WELWYN HATFIELD COUNCIL – DEVELOPMENT CONTROL
DELEGATED REPORT

APPLICATION No:	S6/2011/0991/FP
------------------------	------------------------

The proposal is for a first floor side extension above the existing side extension which was granted planning permission in 2003. The extension will create a fourth bedroom in addition to a family bathroom and ensuite. Proposed on the rear elevation of the first floor extension is a Juliette balcony.

Drawing Title: Elevations		Client: Mr and Mrs David Wheatcroft 12 East View Essendon Herts AL9 6HJ	
Sheet No. 3	of 3	Drawing No:	12EV1-1
Drn: N.A.	Scale: 1:100	Revision: B	Original Drawing Size: A3
Date: May 2011

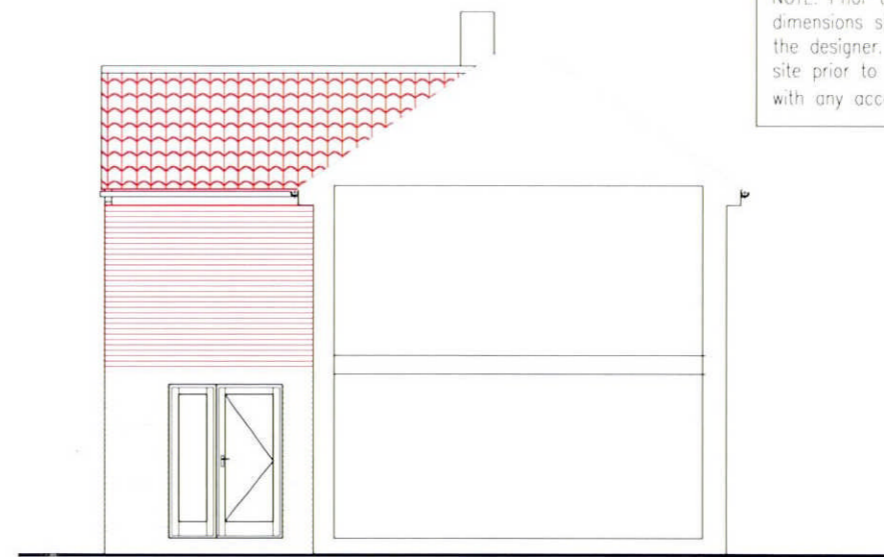
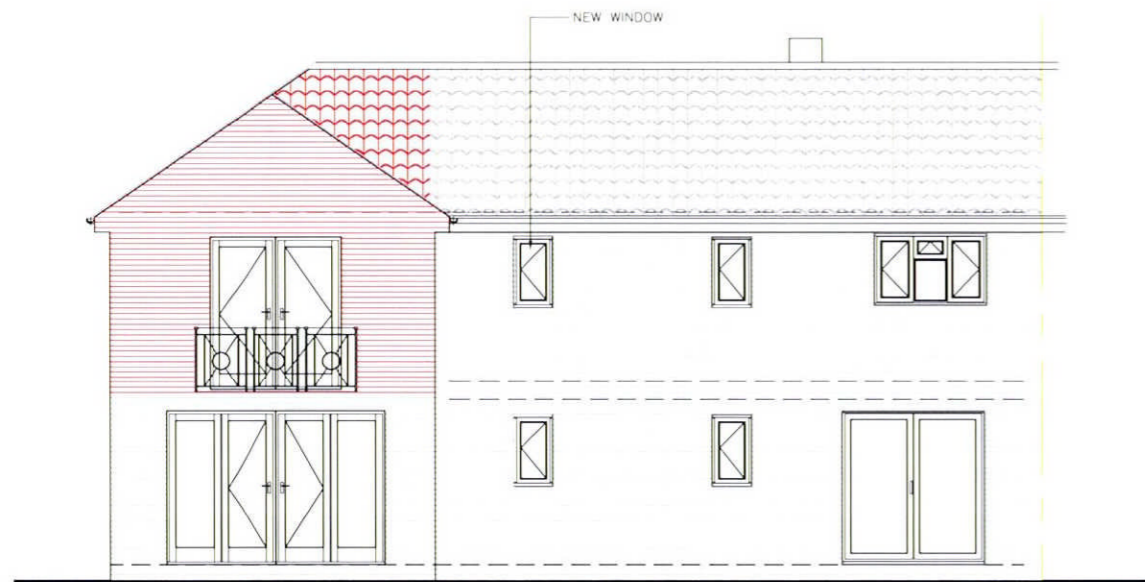
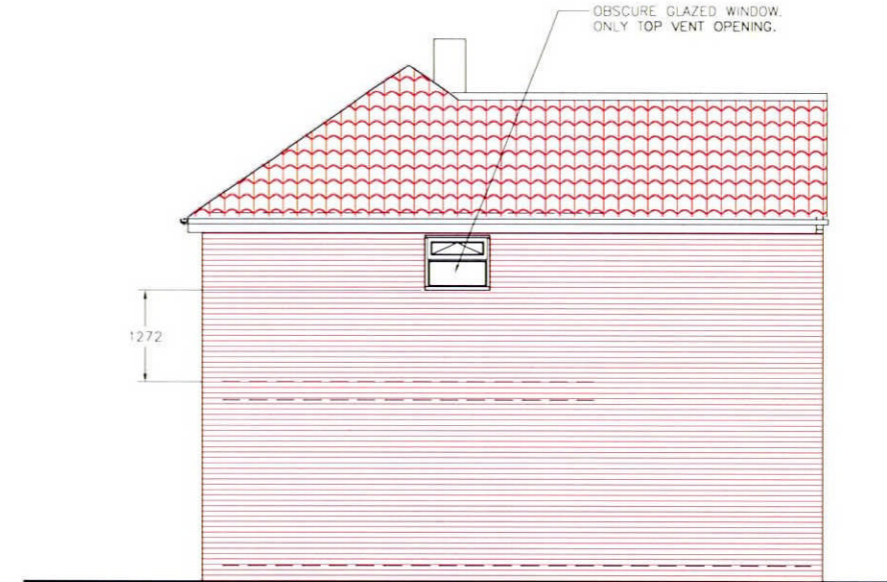
The architectural style, windows, detailing and materials are appropriate to the original dwelling and the design of the scheme does not have an adverse visual impact upon the character and appearance of the existing dwelling. The extension would be constructed of materials that are in keeping with the existing dwelling and the local area. No letters of objection have been received and Essendon Parish Council did not object. An approximate 1 metre separation space would be maintained at first floor level between the flank wall of the extension and the boundary with adjoining dwelling, No.14. The proposal would not have a significant impact on the design and character of the dwelling and surrounding area in compliance with policy D1 and D2 of the Welwyn Hatfield District Plan, 2005.

The proposed extensions would not result in loss of light or have an overbearing impact on the occupiers of the adjacent properties. In the interest of neighbour amenity, the first floor window on the side elevation should remain fixed and obscure glazed by way of a planning condition. The extension would not have a detrimental impact upon the privacy currently enjoyed by neighbouring occupiers. The proposals are in accordance with Policy D1 and Supplementary Design Guidance.

- 1. The site lies within the Metropolitan Green Belt where there is a presumption against inappropriate development. The proposed extension would result in a disproportionate increase that is not subordinate to the scale of the original dwelling. The proposed extensions would have an adverse affect on the open characteristics of the Green Belt as a result of increasing its developed appearance and adding considerably to the bulk of the building. As such, the proposals represent inappropriate development and as no very special circumstances have been advanced of sufficient weight to set aside Green Belt policies of restraint, is contrary to the advice contained in Planning Policy Guidance Note 2 and would conflict with Policies RA3 of the Welwyn Hatfield District Plan 2005.

PROPOSED FIRST FLOOR PLAN

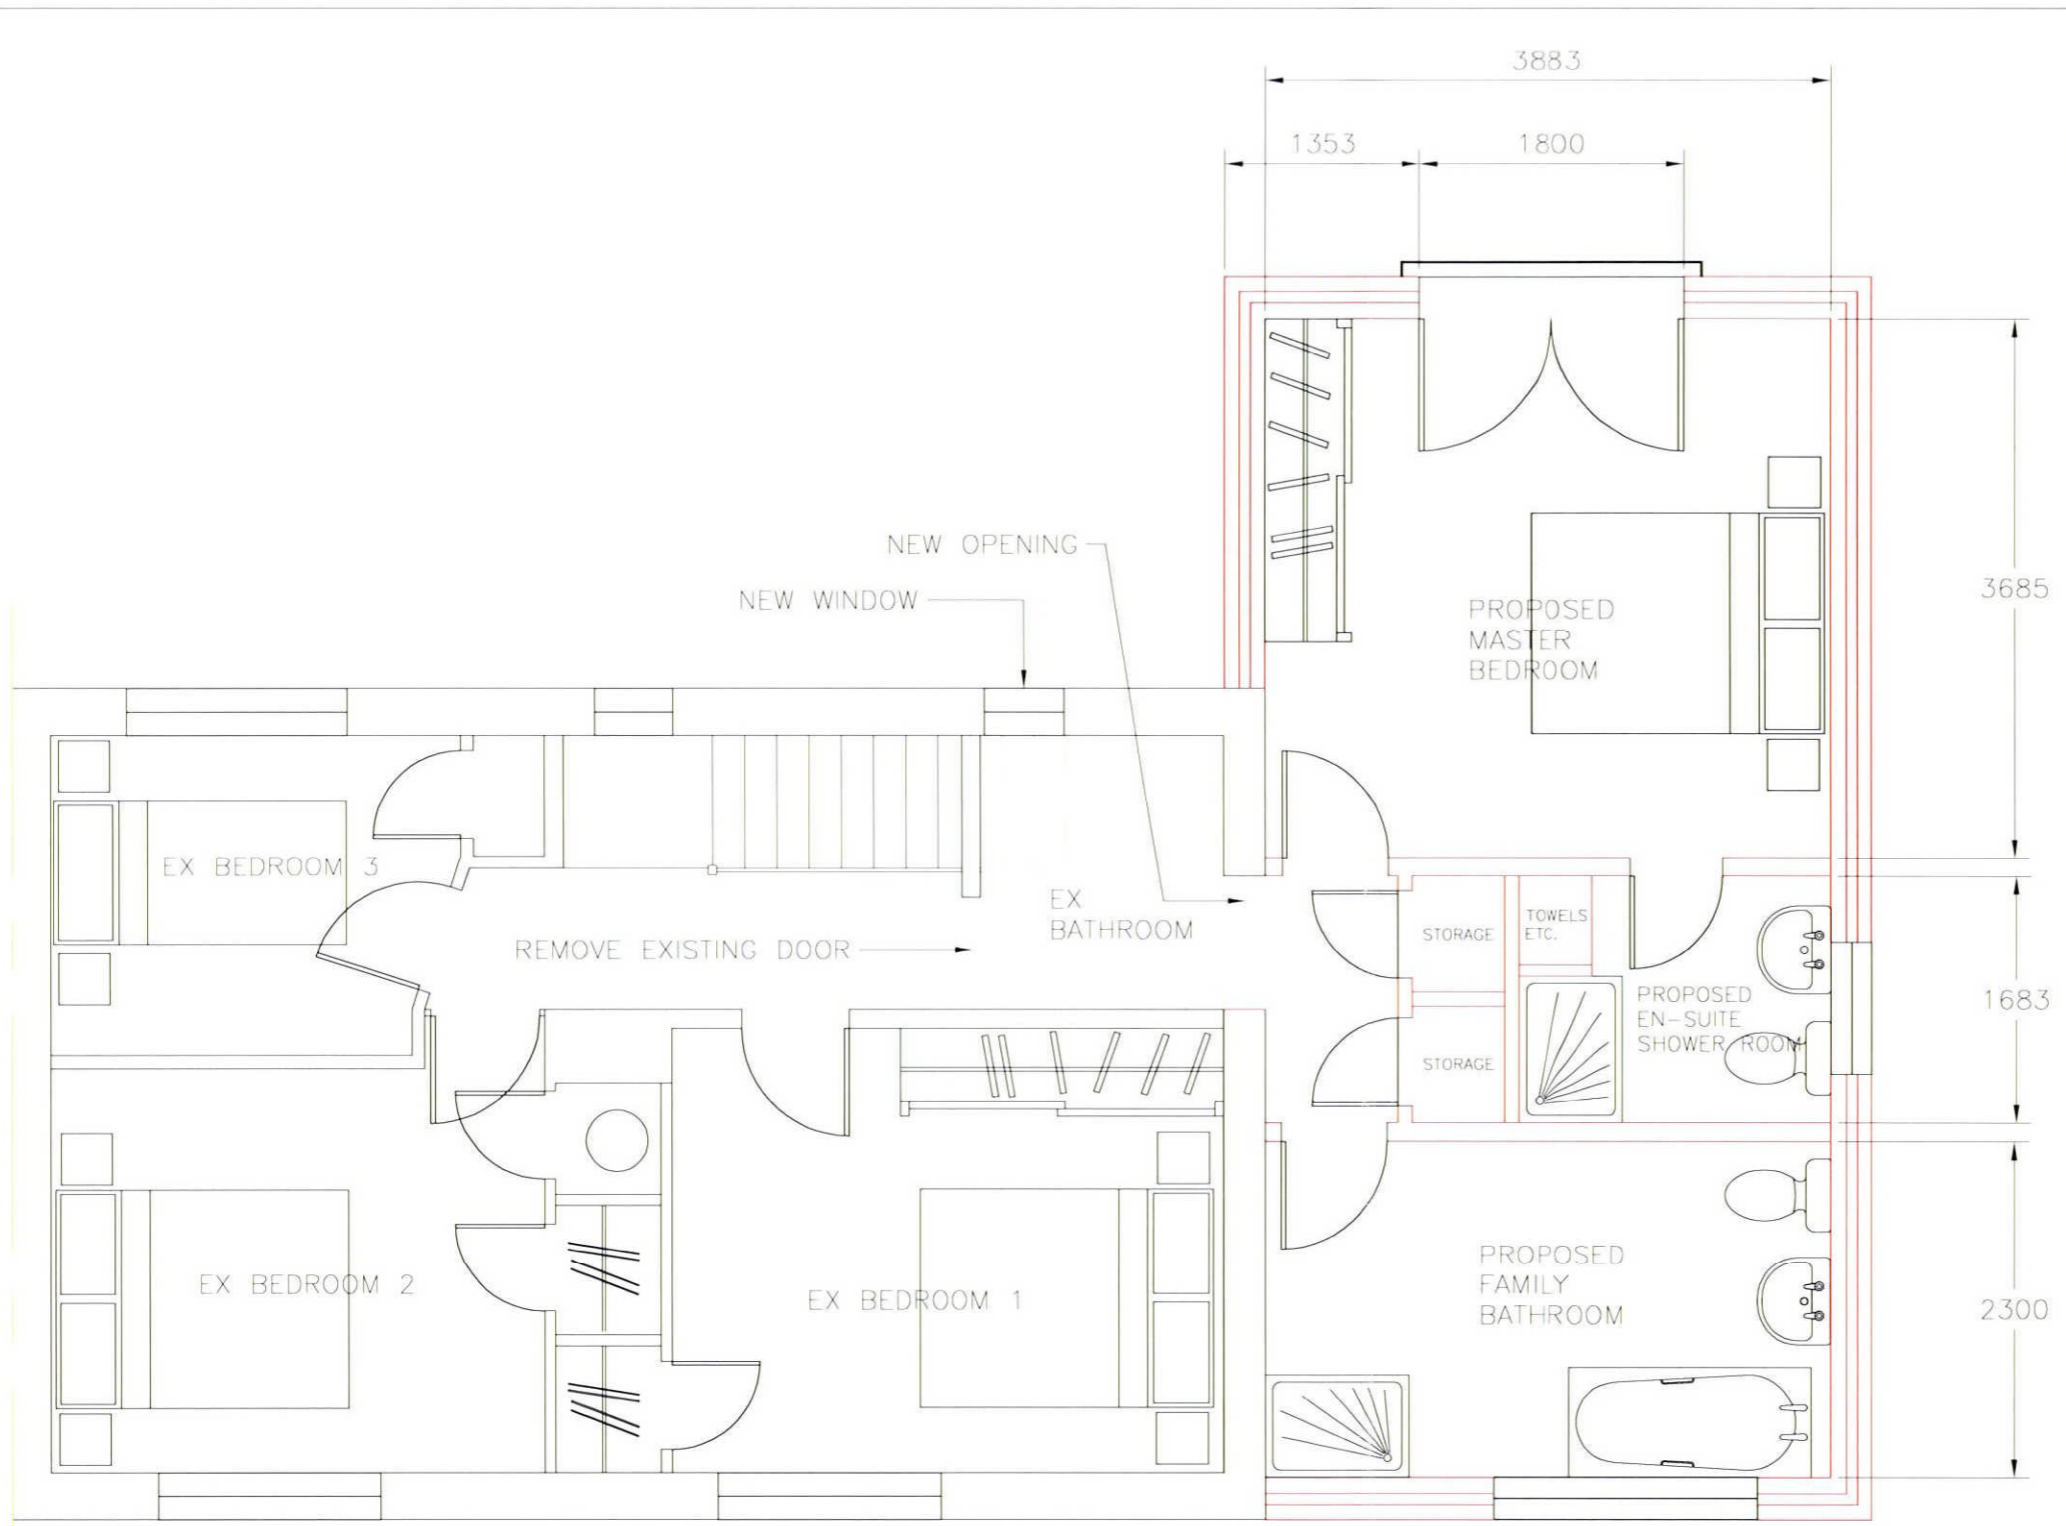
The dwellinghouse has been extended upon previously through a single storey side extension. The existing side extension equates to a floor area of 35.6m² with the proposed floor area of the first floor side extension equating to 35.97m². The floor area of the original dwellinghouse measures 94.98m². The proposal in addition to the existing side extension accumulates in a 71.6% increase upon the floorspace of the original dwellinghouse. The cumulative effect of the proposed extensions in addition to existing extensions would result in a disproportionate increase in the size of the original dwelling. The proposed increase in floorspace would have an adverse affect on the open characteristics of the Green Belt as a result of increasing its developed appearance and adding considerably to the bulk of the building. The proposed extension does not constitute an appropriate form of development within the Green Belt and no very special circumstances have been given that would justify the approval of this proposal and therefore fails to comply with National Planning Policy Guidance 2 Green Belts and Policy RA3 of Welwyn Hatfield Council District Plan 2005.
